# CITY OF ALBUQUERQUE

**Re: Estates at Glendale Ph III-Ashton Homes  
Erosion and Sediment Control Plan  
Engineer's Stamp Date 5-7-18 (B19E027)**

## EROSION AND SEDIMENT CONTROL PLAN

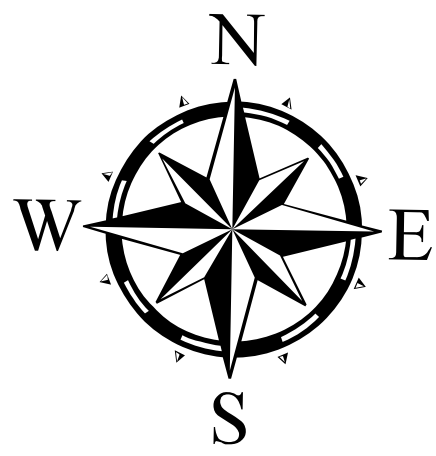
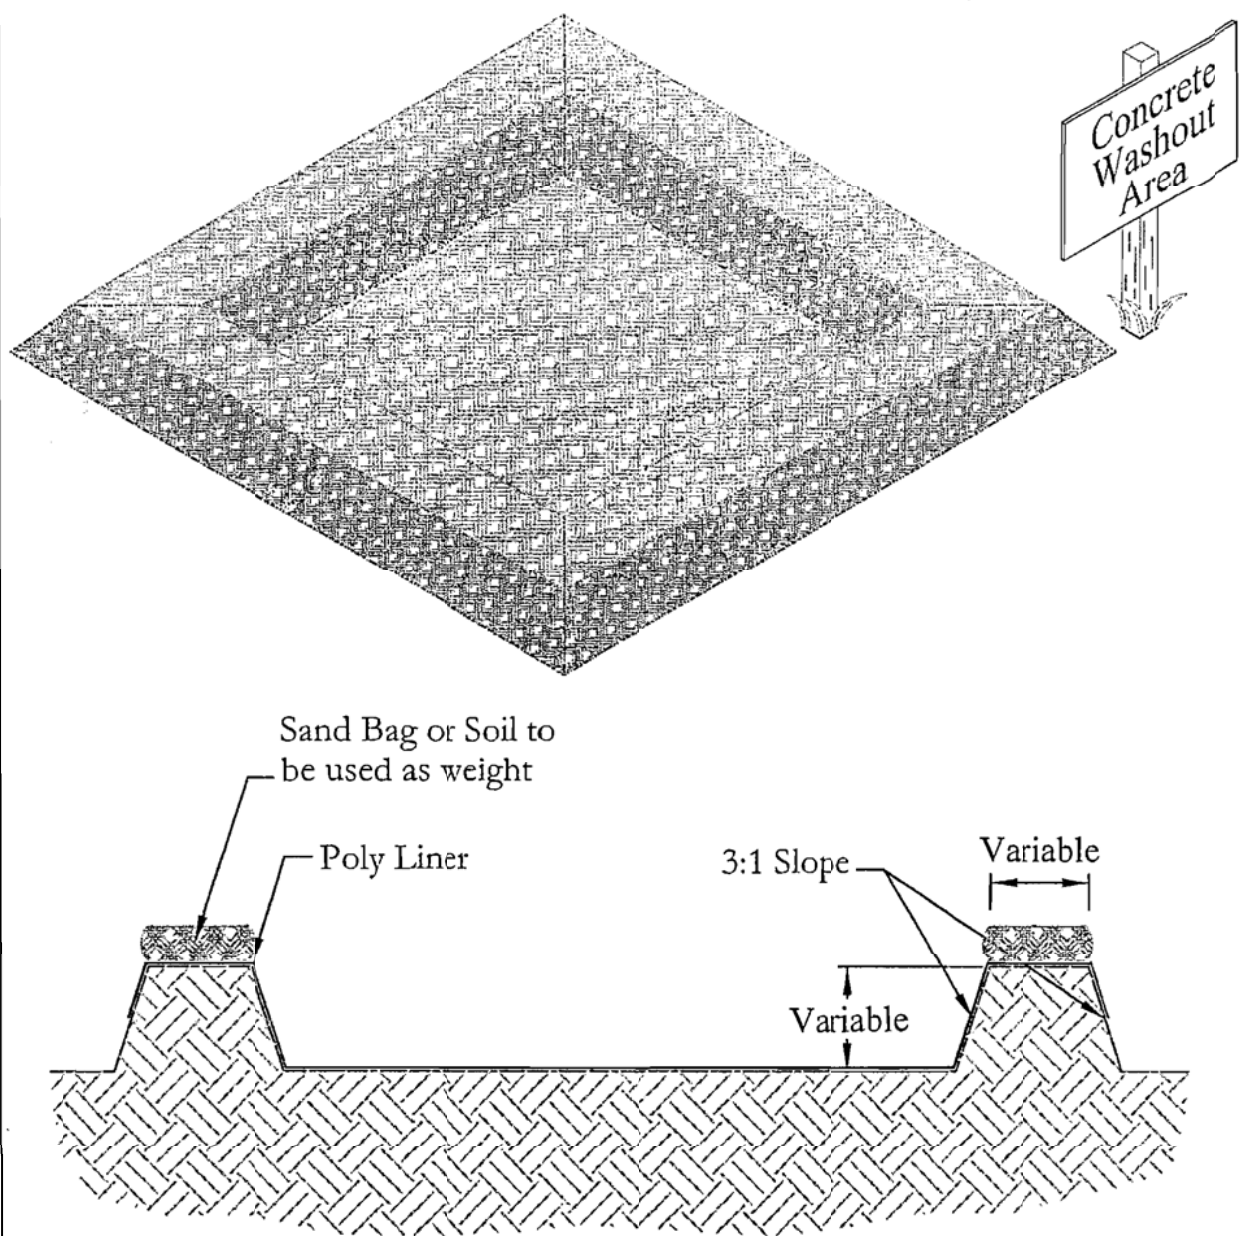
1. A sediment BMP (cutback behind the curb, silt fence or mulch sock is required behind the curb on every lot.
